Engineers Comments Regarding Surface Water Drainage

Application Reference:	LU/100/26/DOC	Reviewer Reference:	ADC/EXT5/AF
Planning Officer:	Kathryn Welch	Date of Review:	18/06/2026
Site Name:	Ambulance Station East Street Littlehampton BN17 6AU		
Application Description:	Approval of details reserved by condition under LU/45/24/PL relating to conditions 18- Surface Water Drainage Scheme and 19- Maintenance & Management of Surface Water Drainage System.		
Assessment Number:	2

Application Reference: LU/100/26/DOC Site Name: Ambulance Station East Street Littlehampton BN17 6AU	Initial Issue Date: 15/01/2026 Issue Date: 18/06/2026 Reviewer Reference: ADC/EXT5/AF
---	--

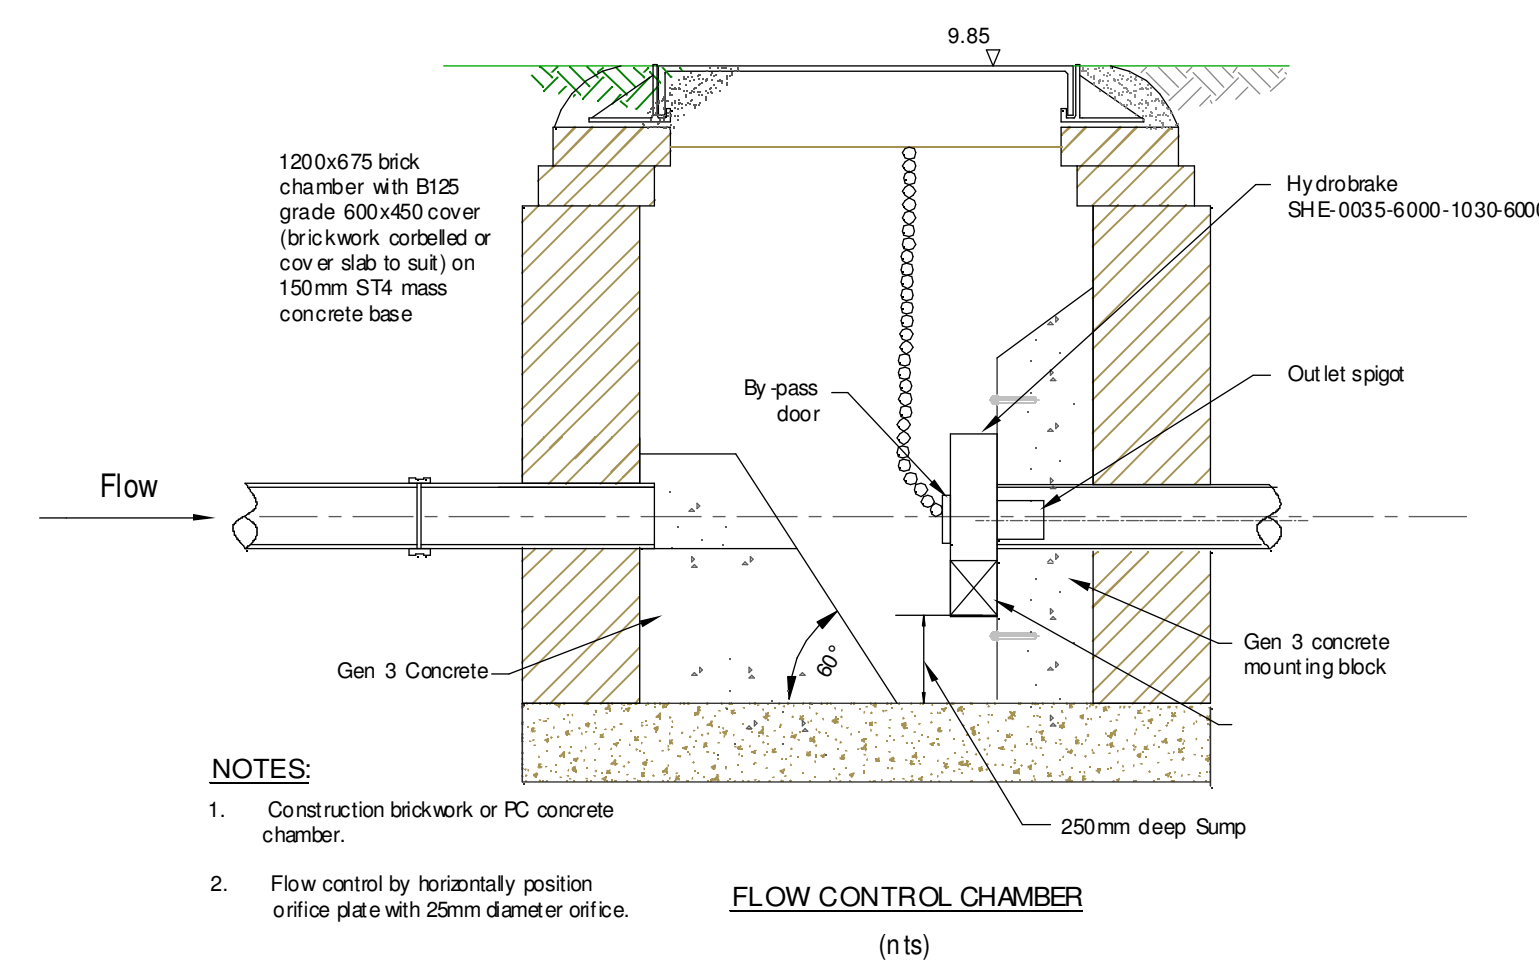
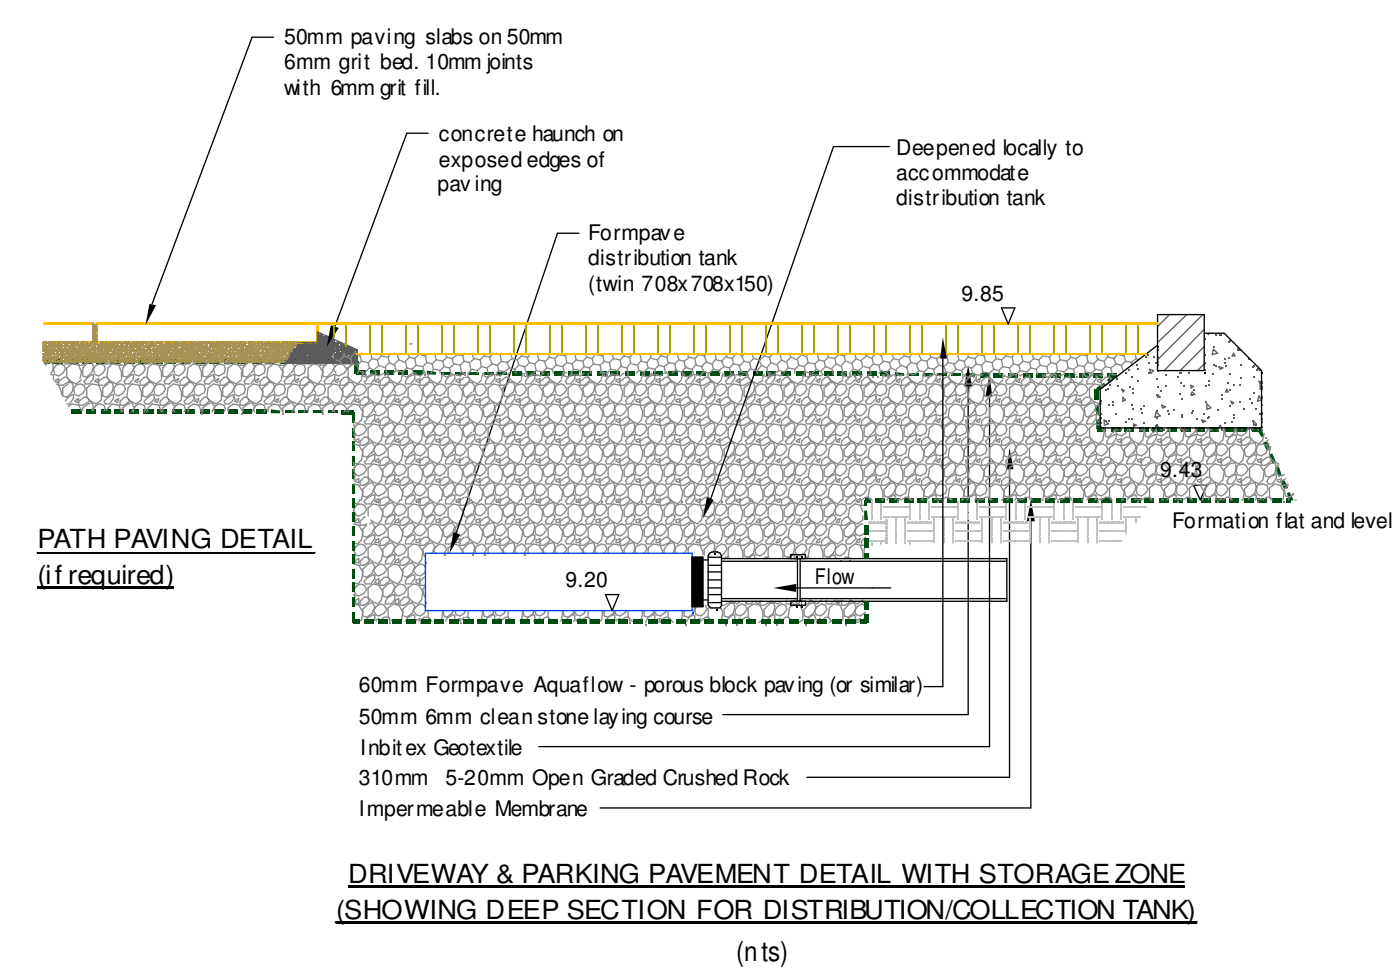
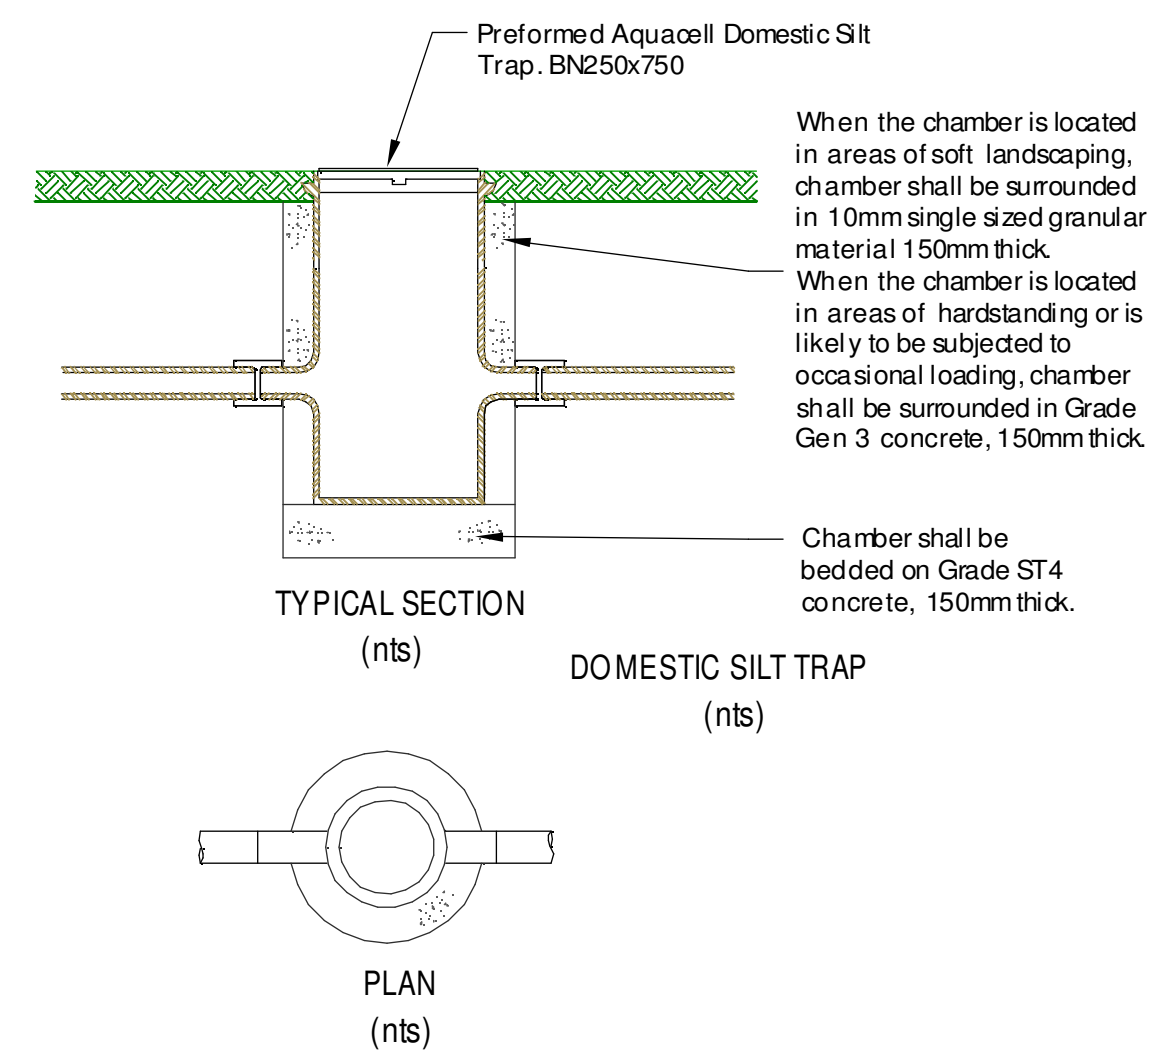
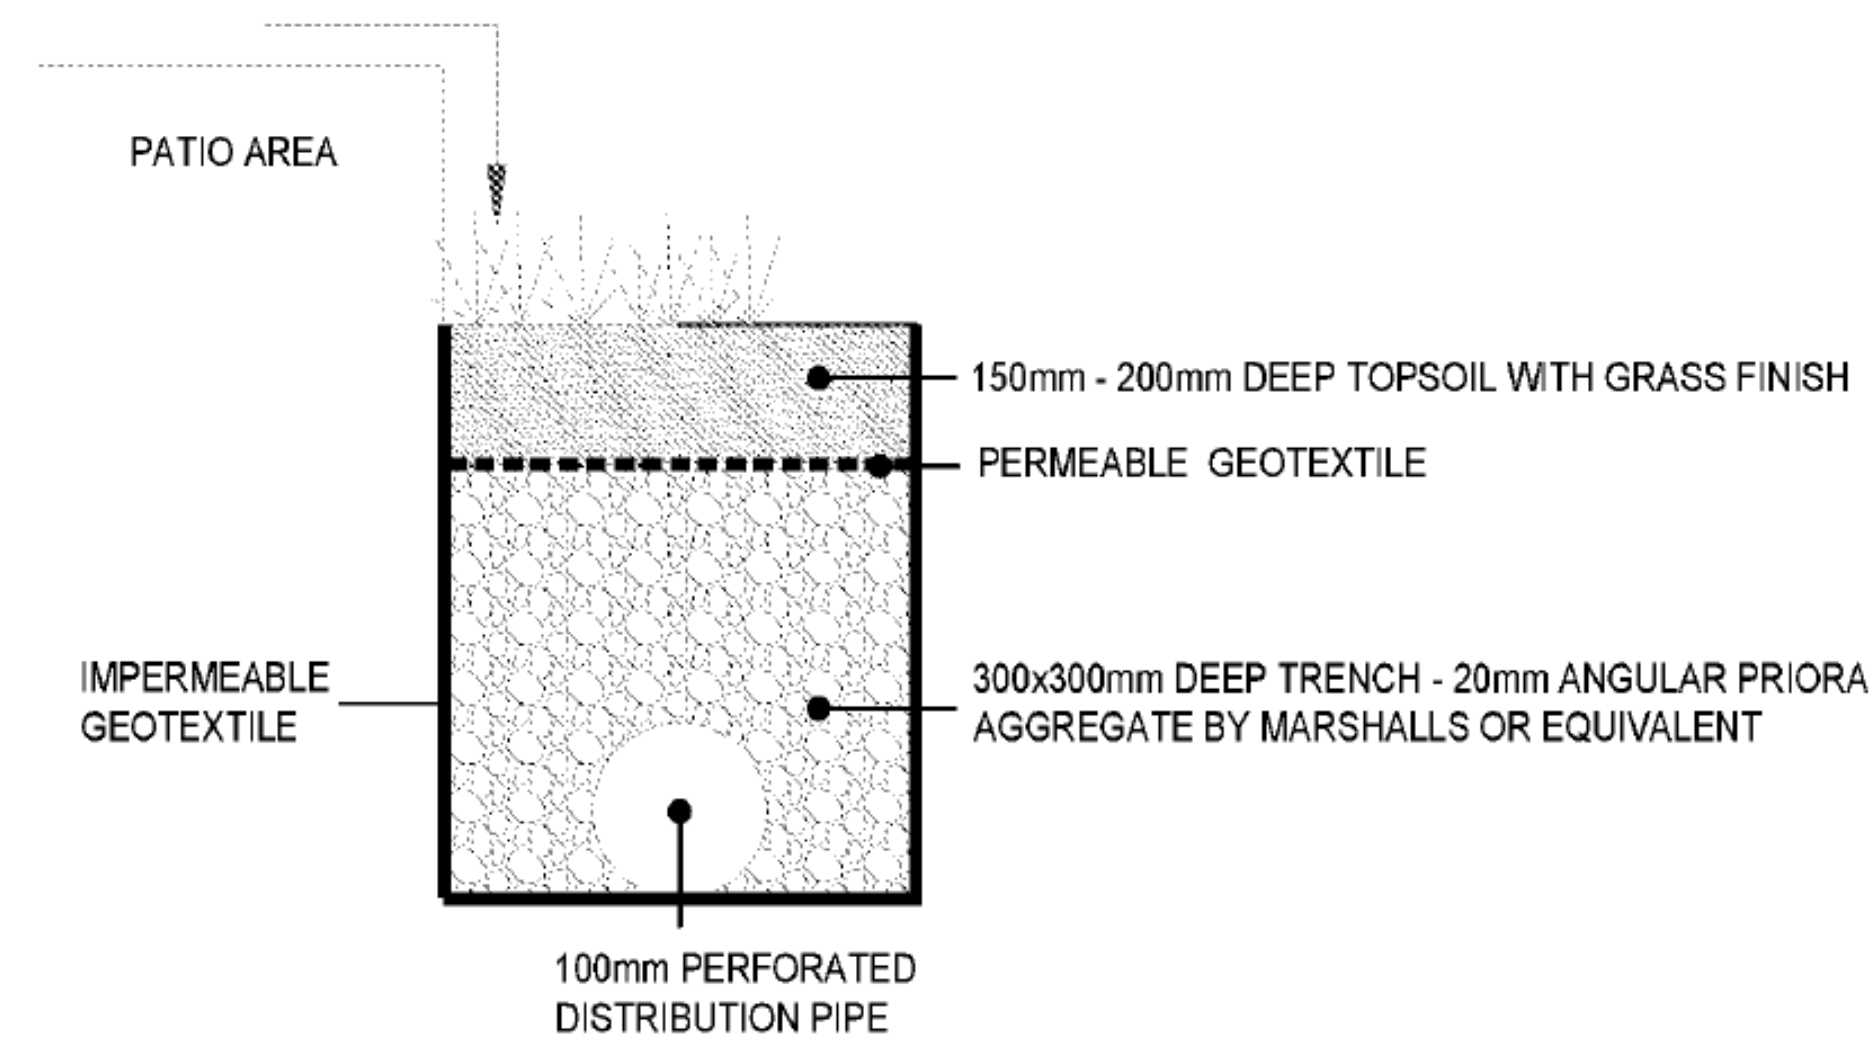
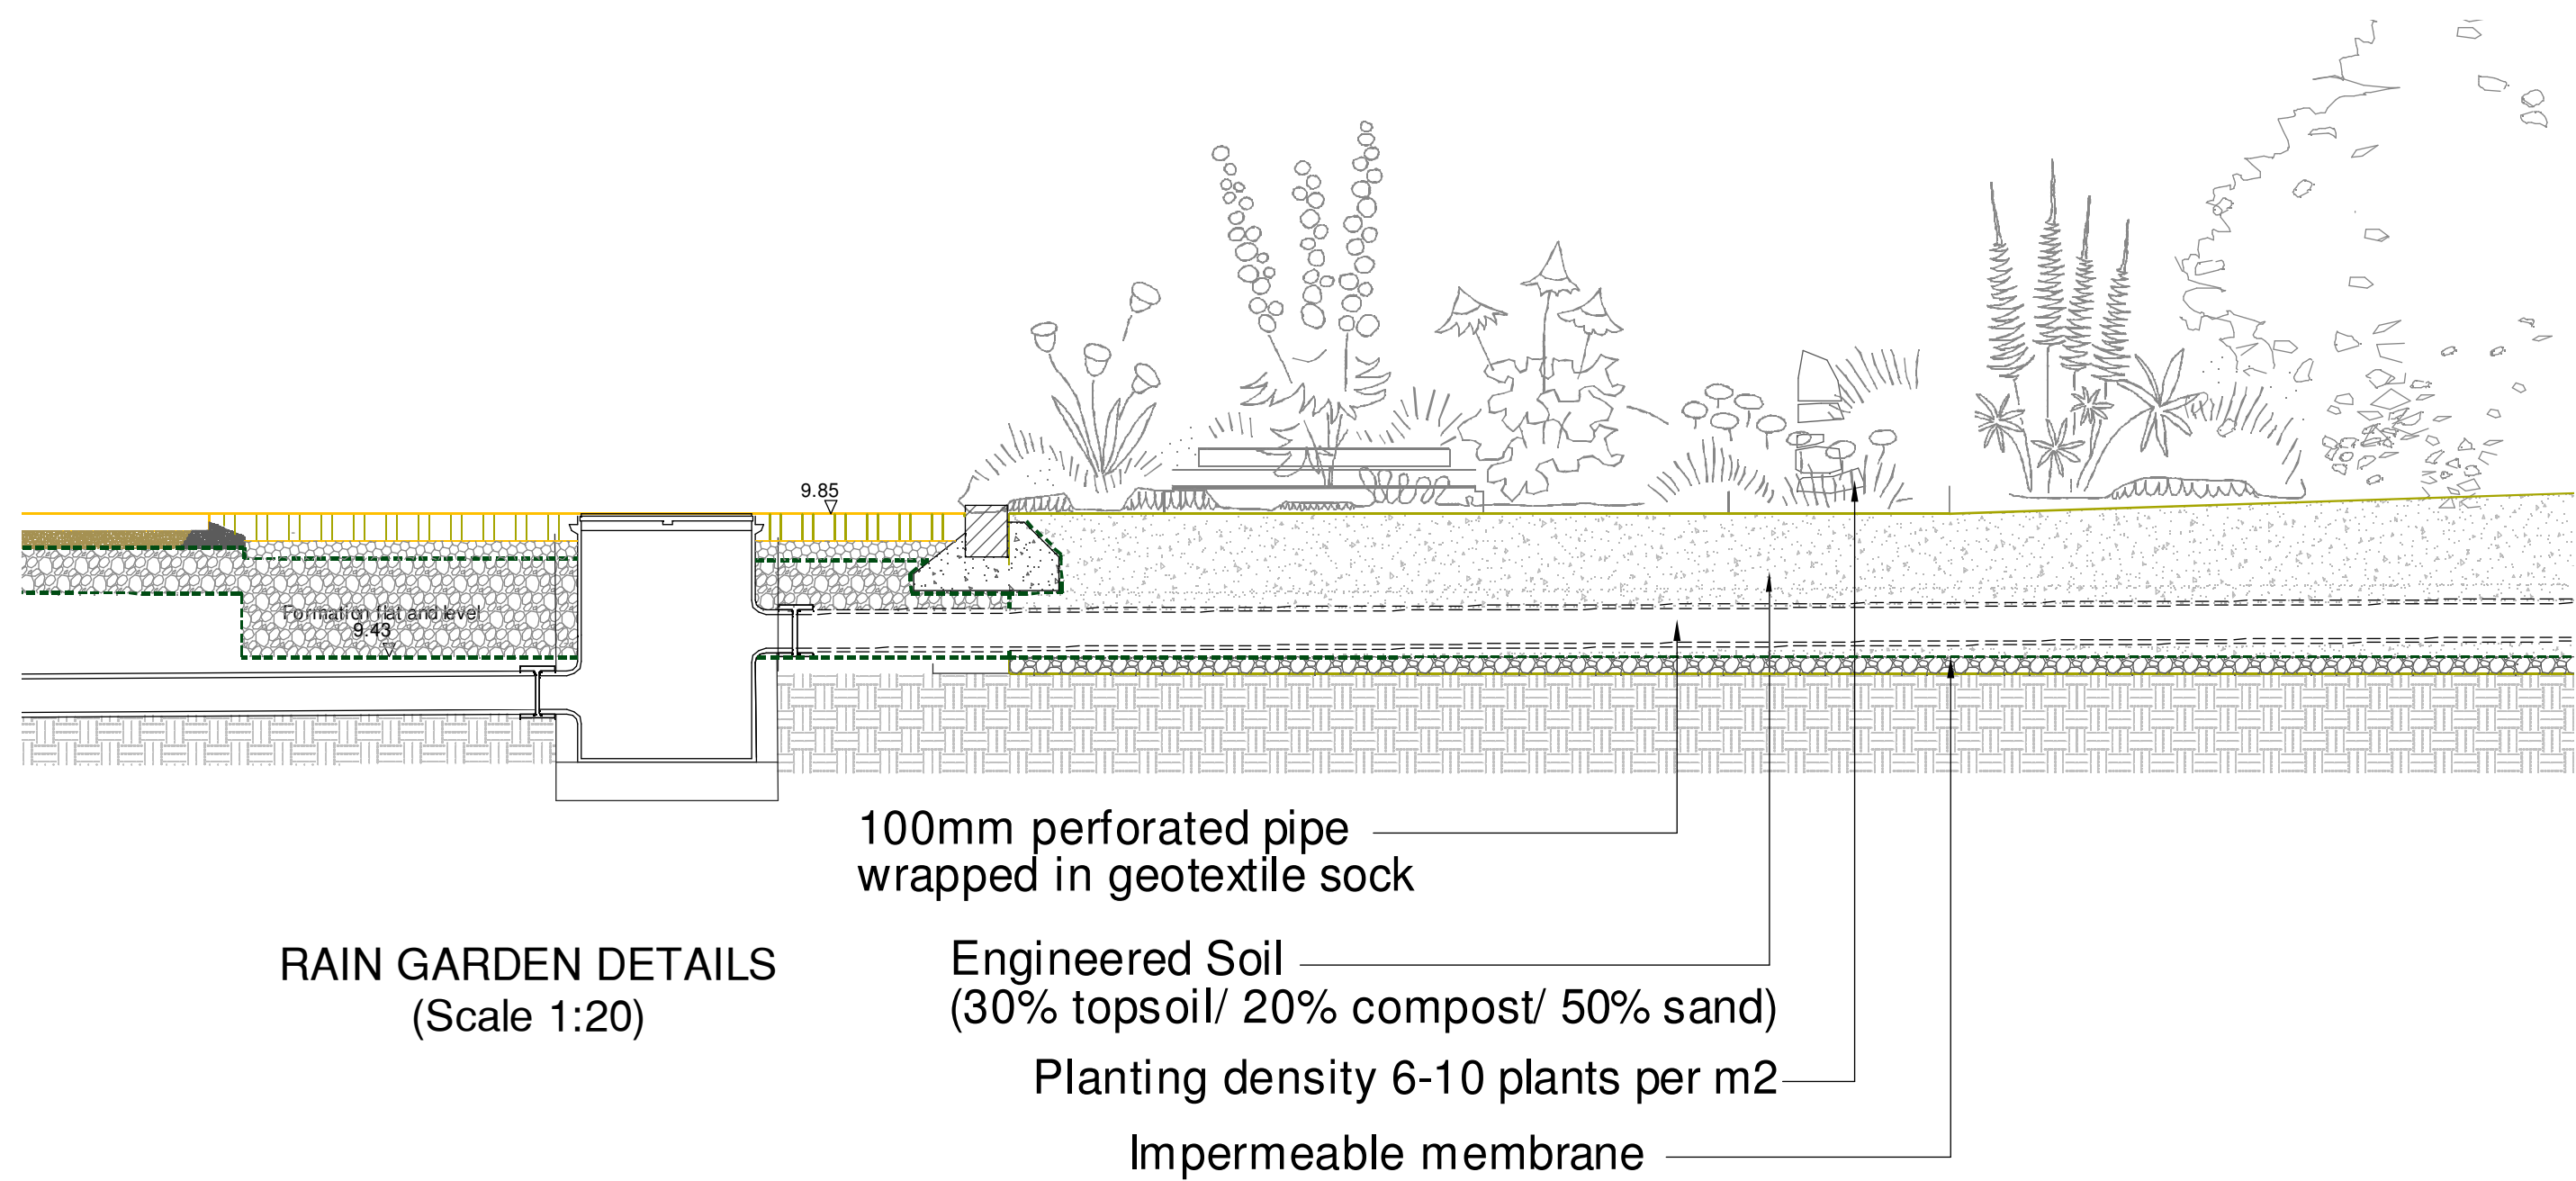
5.	The proposed flow control device has a small orifice and could be susceptible to blockage as there are currently upstream inputs not filtered through the permeable paving. The mesh grill is noted and we would also wish to see a high level overflow to prevent flooding in the event of blockage. Consideration should also be given to filtering rainwater from roof areas prior to discharge	The upstream drainage appears to be filtered through sustainable drainage methods but the perforated pipes through the filter drains could convey detritus from downpipes and a risk of blockage to the relatively small flow restriction (35mm) remains. Further clarification of the design to remove the risk of blockage from the flow control device is needed. ADC Drainage Comments 15/05/2026 The design is not clear enough that the connection from the downpipes do not	Silt traps added to downpipes that connect to the perforated pipe. Gravel traps added to downpipes that discharge directly to raingarden surface. S1 and S2 are also silt traps for added protection of flow control chamber. peak flow. The layout plan should also clarify the arrangement as it currently appears to show short lengths of pipe.	Comment closed.

join directly to the perforated collector pipe in the raingardens. A detail is needed to specify the outlet from the rainwater pipes to ensure the flow is filtered as there is no additional blockage protection at the flow control chamber and the restriction is necessarily a very small opening to achieve the desired peak flow. The layout plan should also clarify the arrangement as it currently appears to show short lengths of pipe.

9.	Water butts shown at planning stage are missing from the design	Comment closed.			
Condition Number: 19					
Comment Number					
1.	The MMP should include all aspects of the sustainable drainage system.	Comment Closed.
